CITY OF ALBUQUERQUE

**Re: Albuquerque Collegiate Charter School
Neighborhood Impact Assessment (L09D032)**
Engineer's Stamp DRAFT-No date
Via email: jbecker@tierrawestllc.com

The subject Neighborhood Impact Assessment (Study) DRAFT received on December 13, 2024, has been reviewed by the City of Albuquerque Planning Development Transportation Section. Transportation provides the following comments to be addressed.

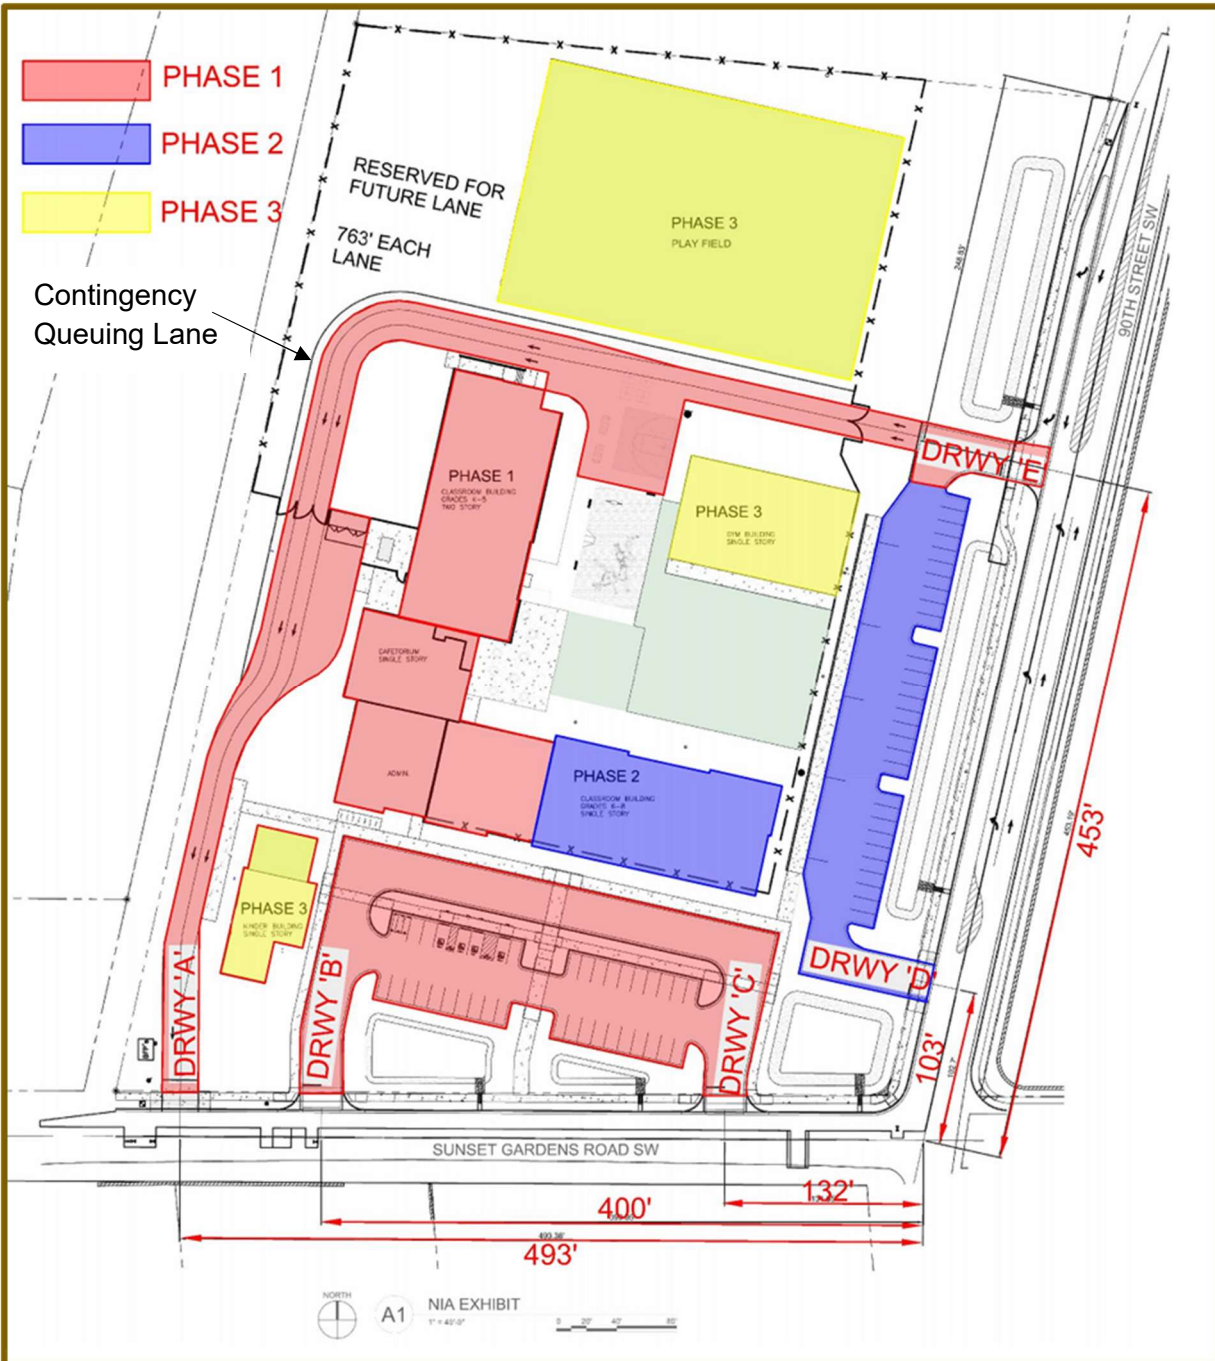
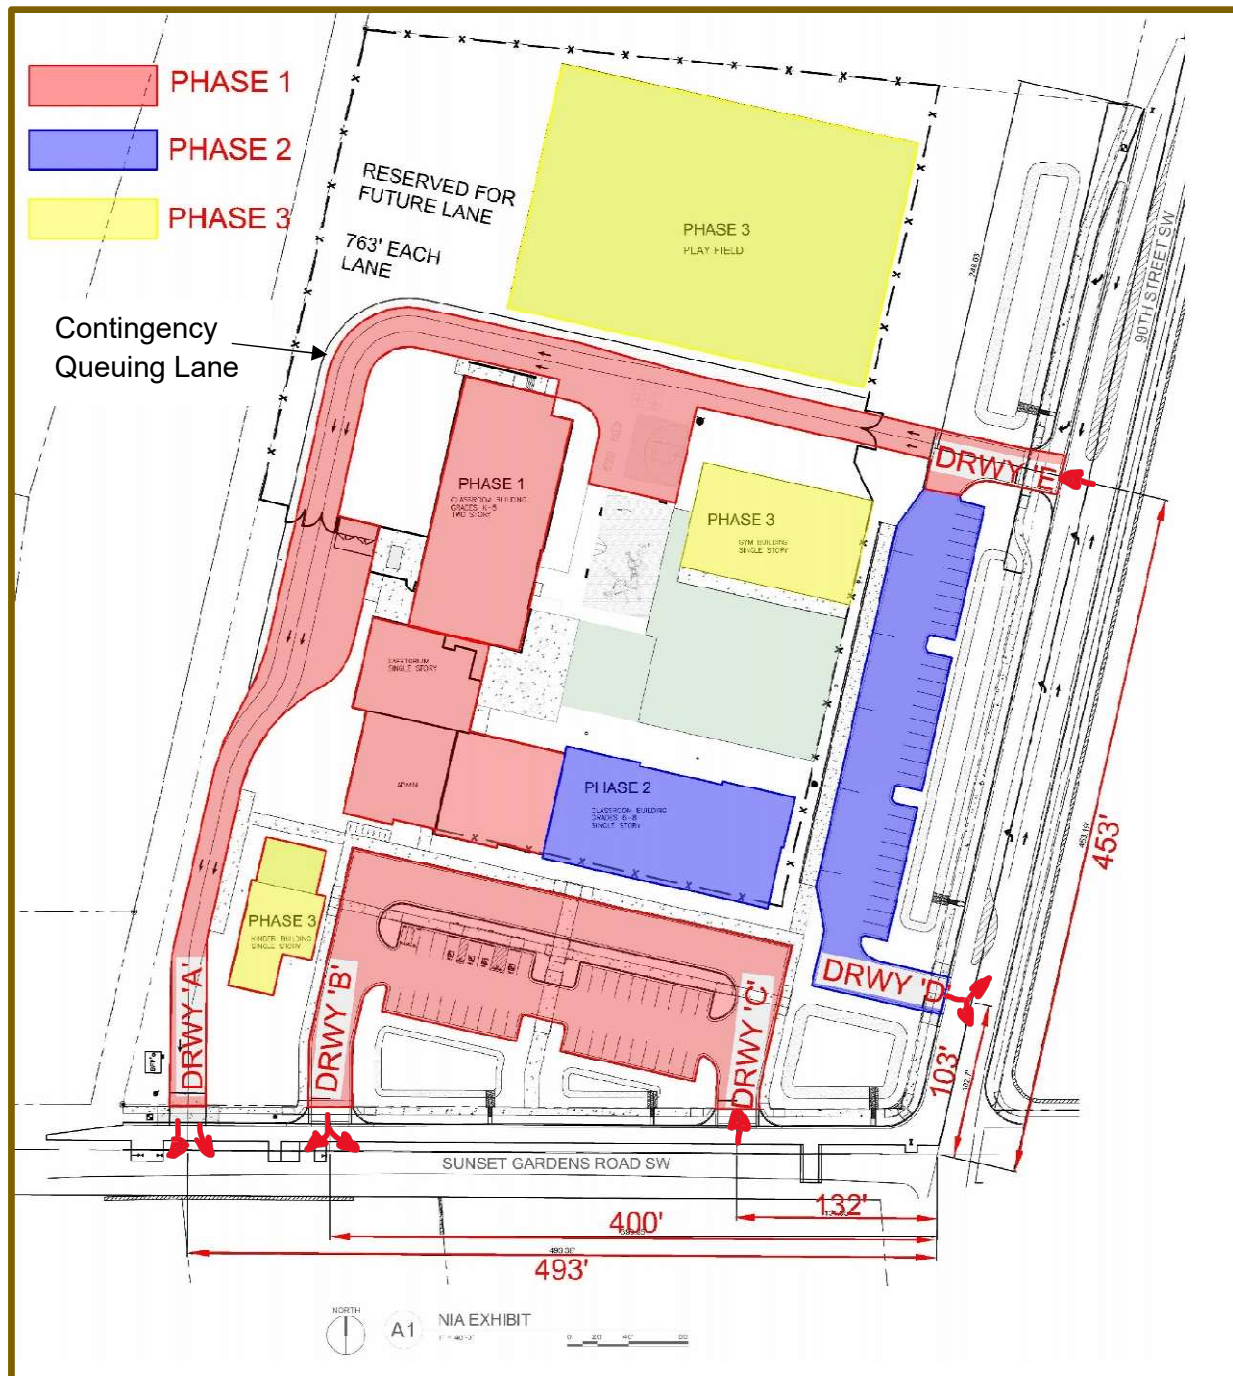
1. Include distances from intersections to driveways and a directional arrow for the south parking lot on the Site Plan. Site plans are not constrained to fit on the 8.5x11 size paper of the Study. Provide a Site Plan minimum size of 11"x17".

2. Identify the Phase on the Masterplan for the south parking lot.
3. Include the queue length, in addition to the delay, for LOS F turning movements in the "Impacts" section.

Albuquerque Collegiate Charter School
 (Sunset Gardens Rd. SW/ 90th St. SW)
 Trip Assignments (% Entering)
 Public Intersections in Study Area

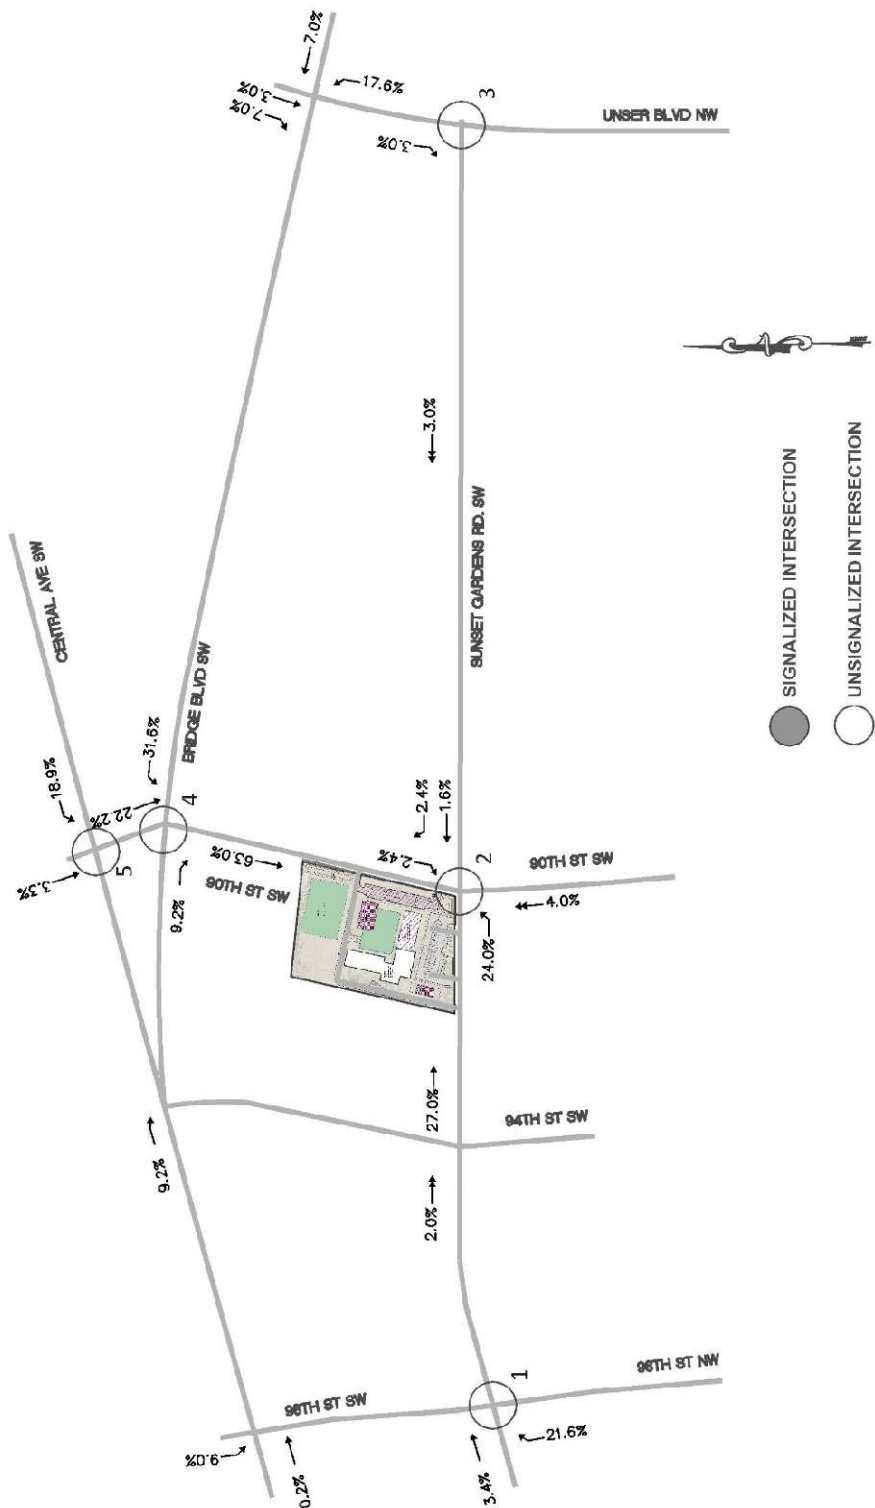
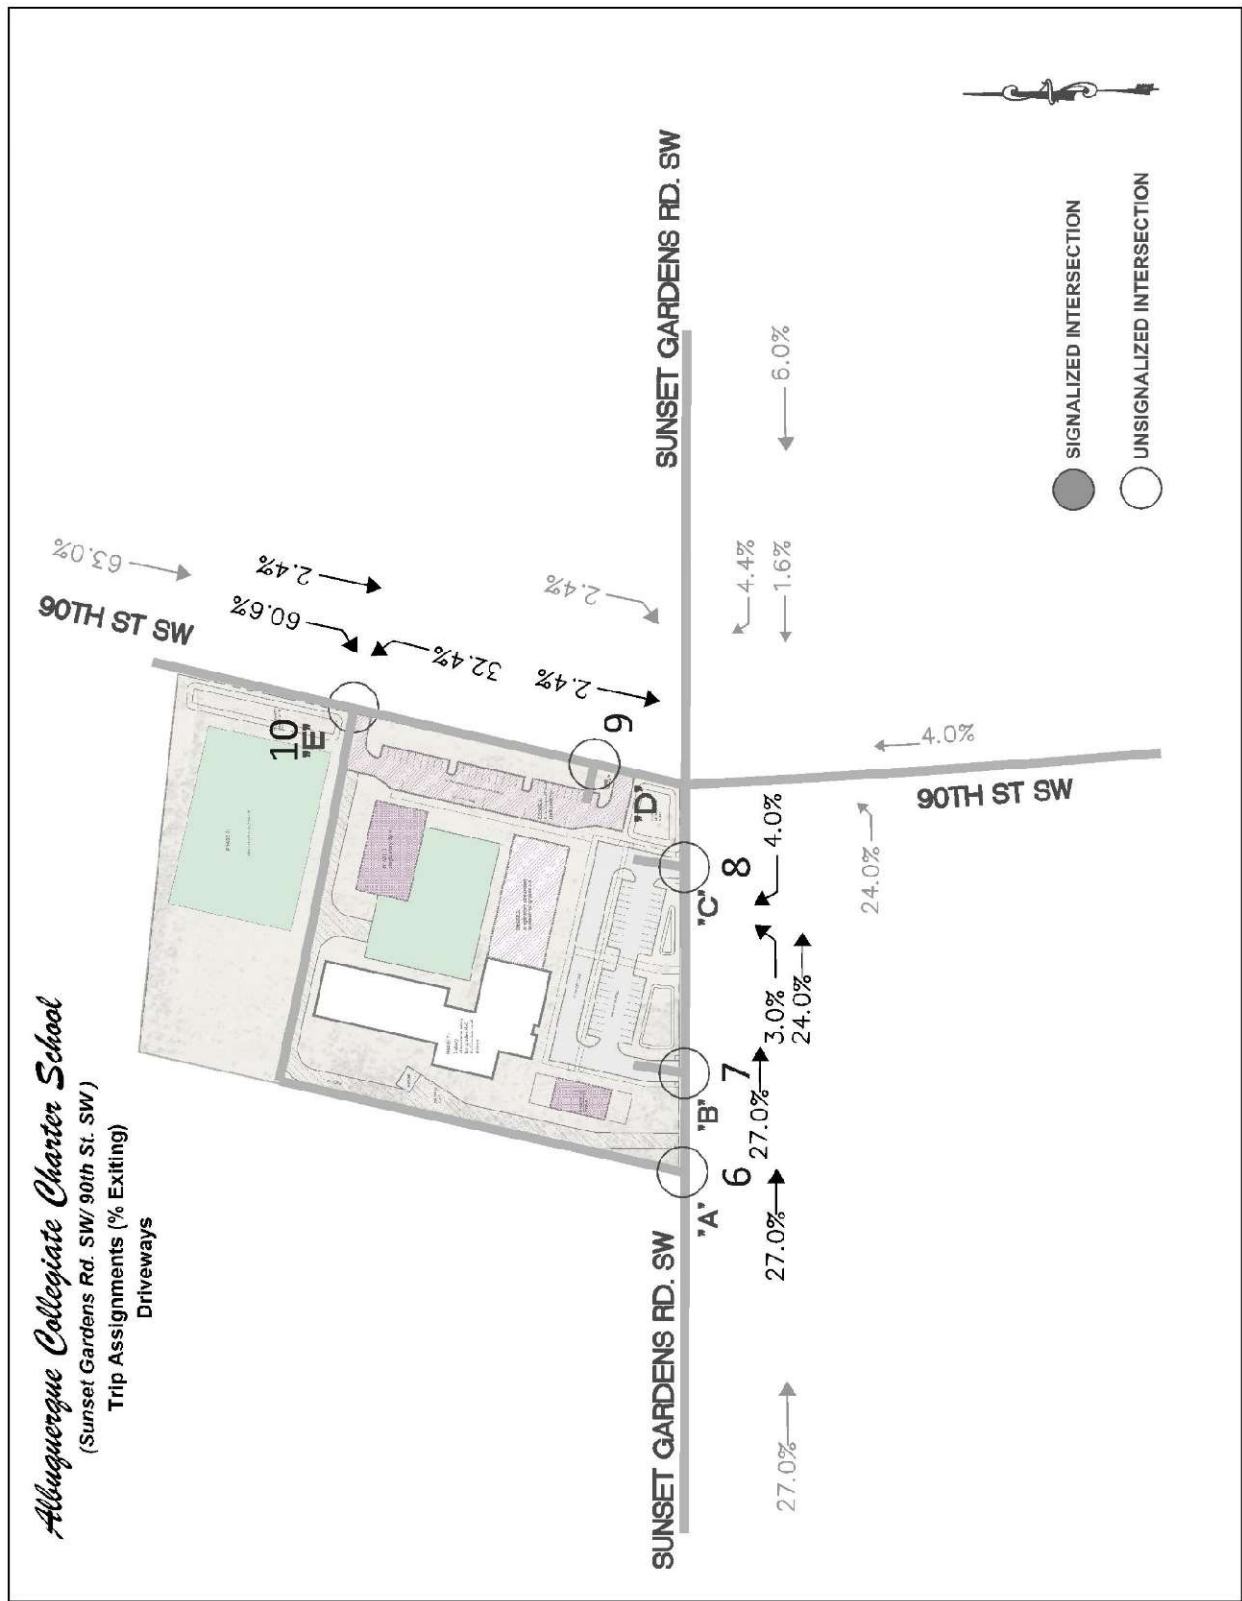
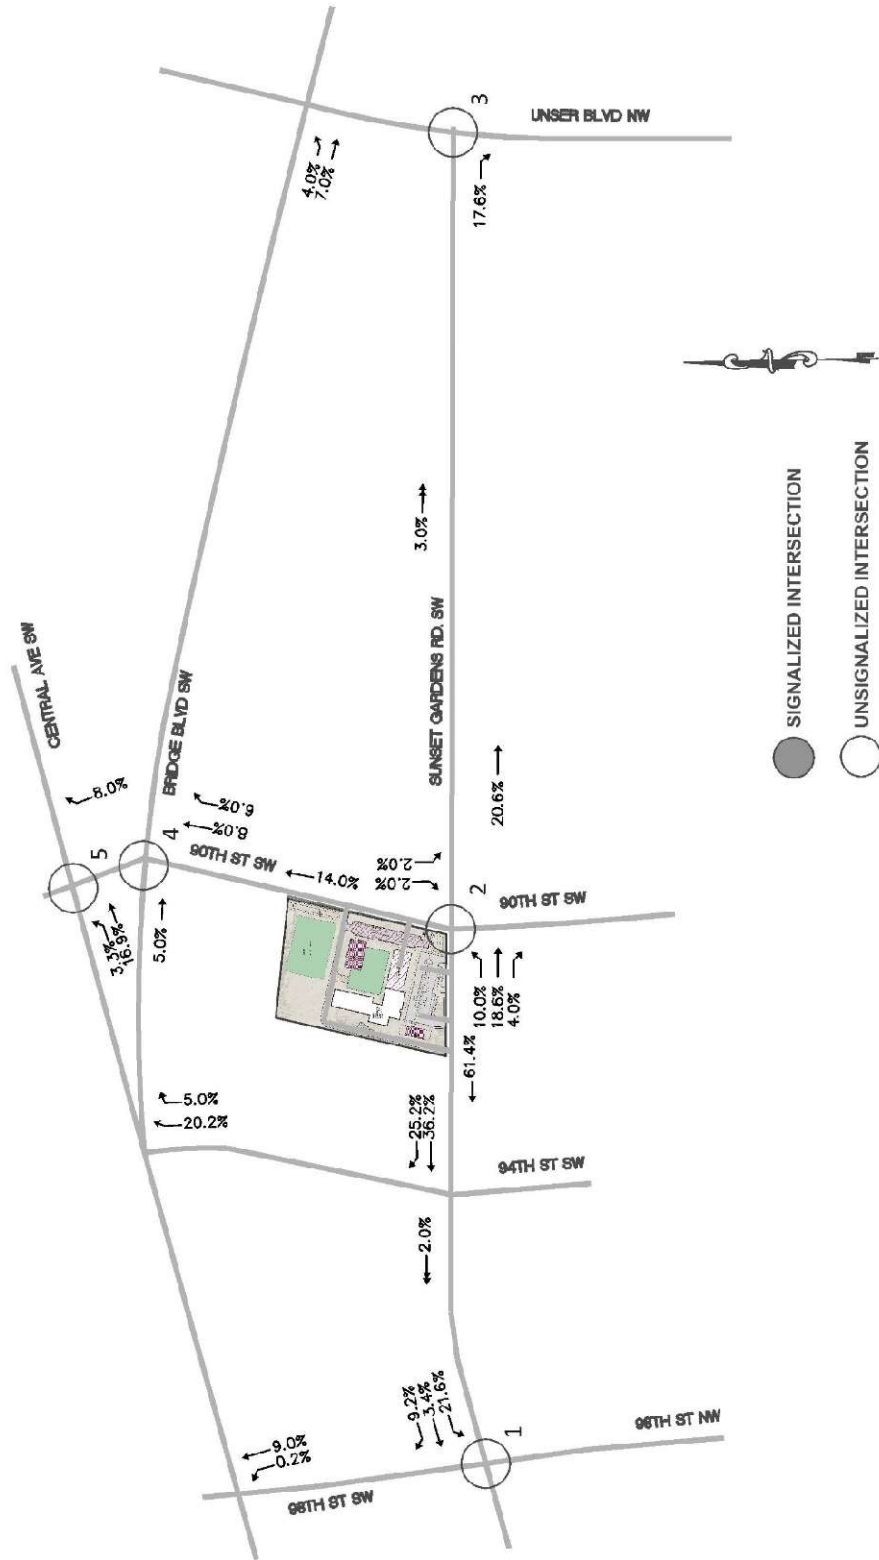
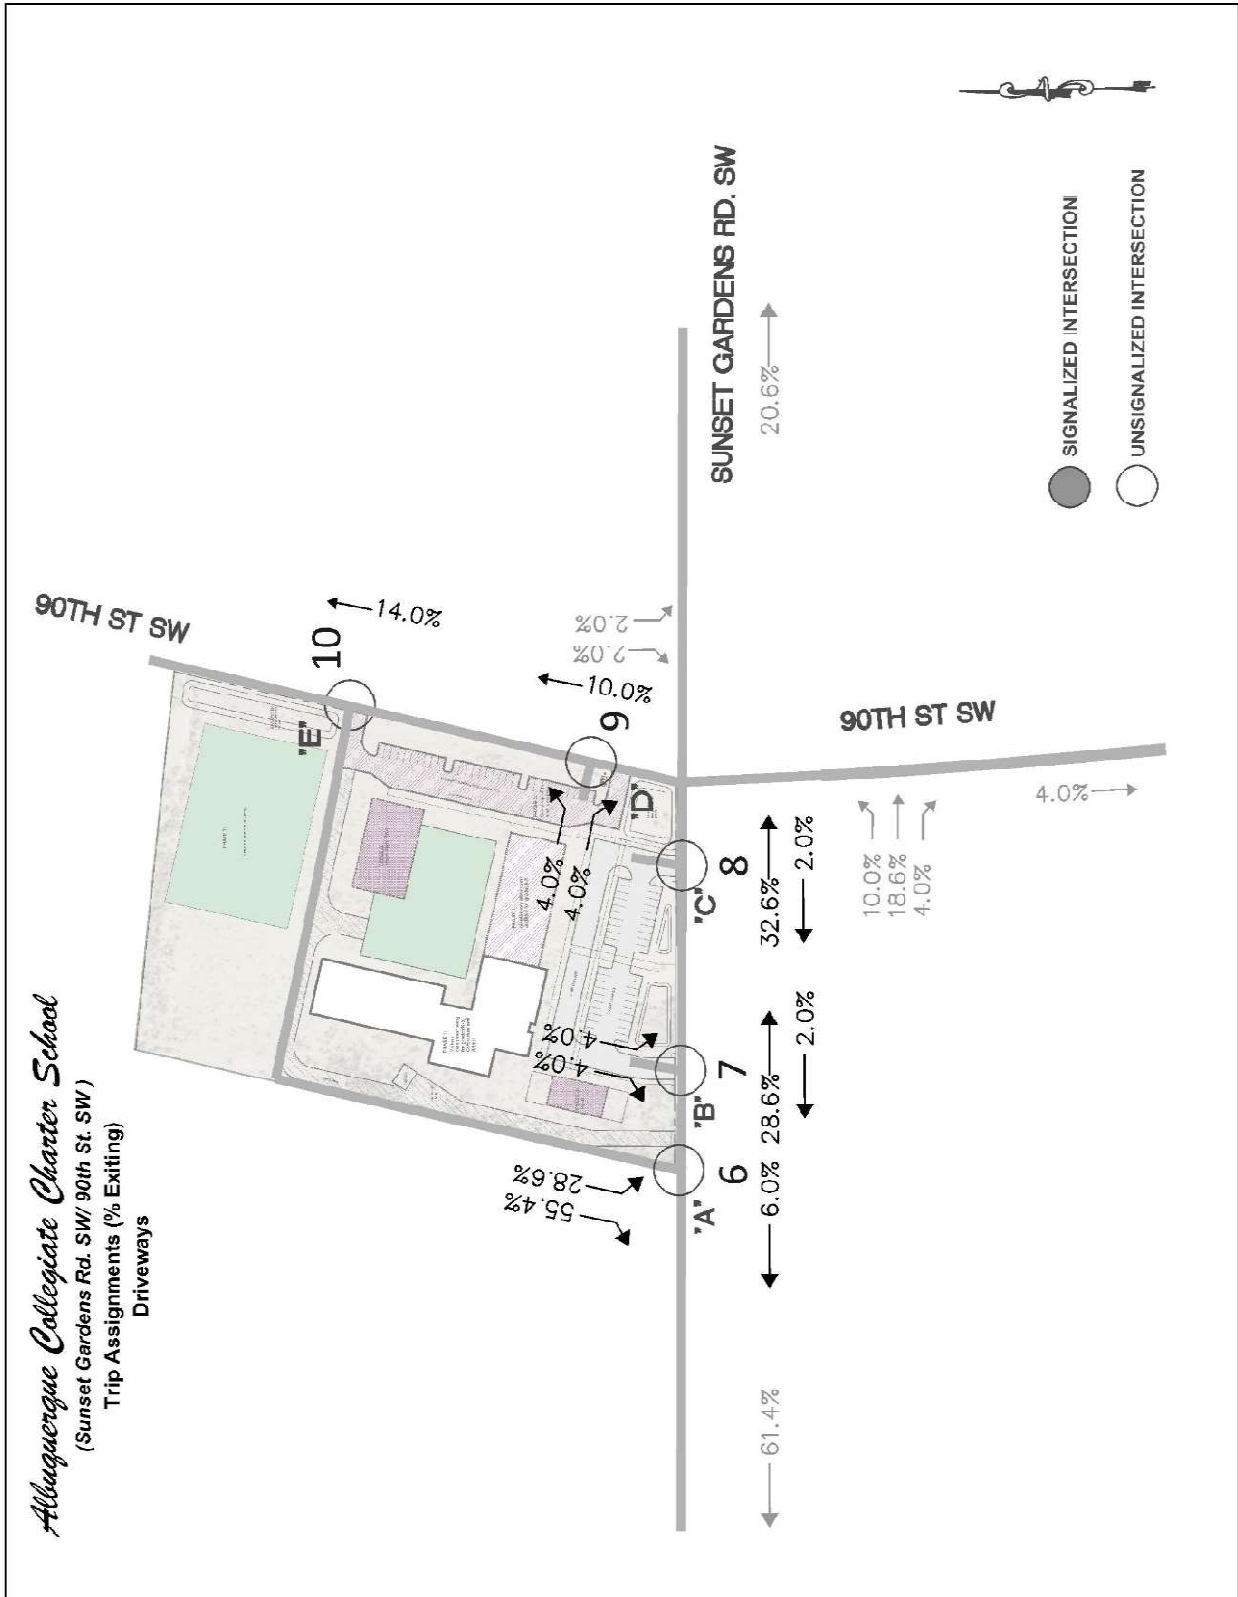
9. The trip distribution of a three-mile radius differs from the Scoping Meeting wherein the boundary was "Use population area-wide ..." Trip distribution percentages appear to be the same as the exhibits that were presented in September 2024. Please explain.
